Submission by Mallard Pass Action Group (MPAG)

Deadline 6:

Comments on Responses to ExA's further 2nd Written Questions

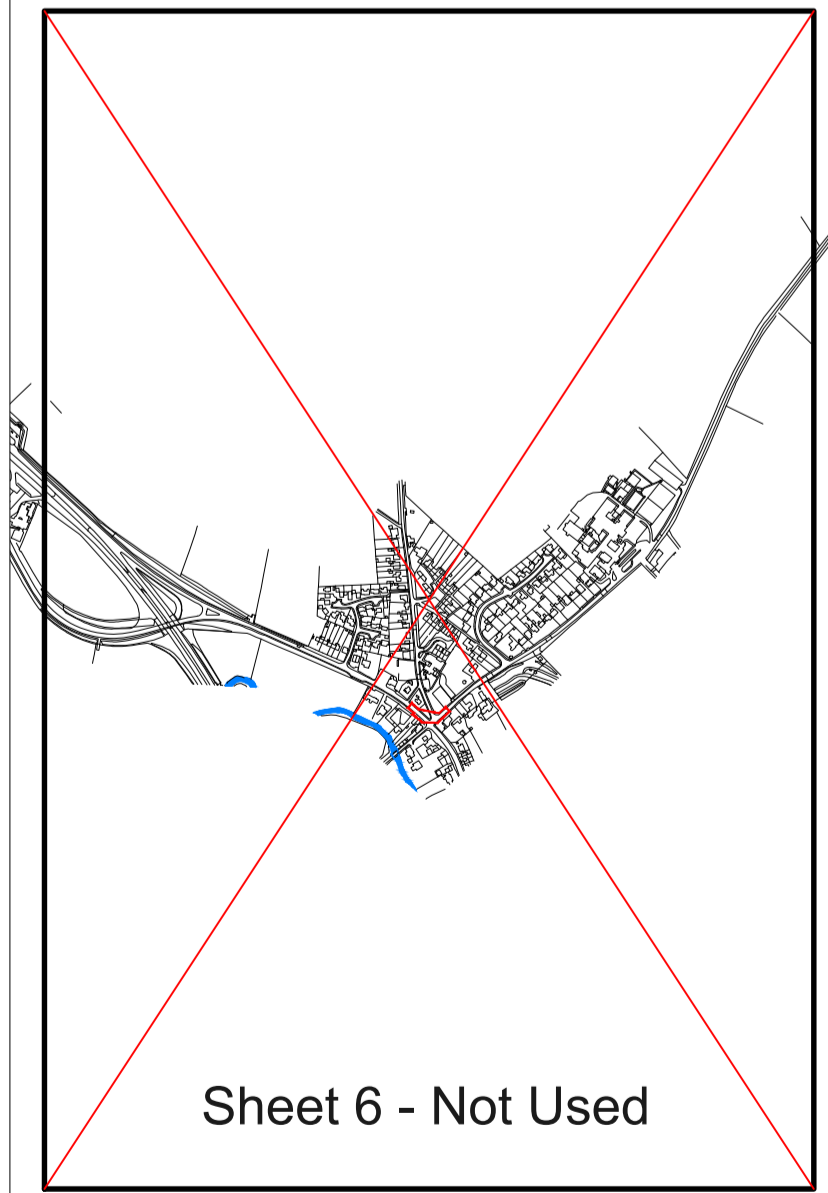
- *Planting up and managing the boundaries of the Solar PV Areas; to prevent and deter unauthorised access from the highway;*
 - *Planting up alongside perimeter fencing which isn't located alongside an existing hedgerow as shown on the Green Infrastructure Strategy Plan [APP-173];'*

However, some DOCOs (for example, Suffolk Constabulary) are now recommending that, 'where appropriate, security fencing systems are transparent to facilitate observation from outside the site'; planting along fence lines would not allow the required transparency.
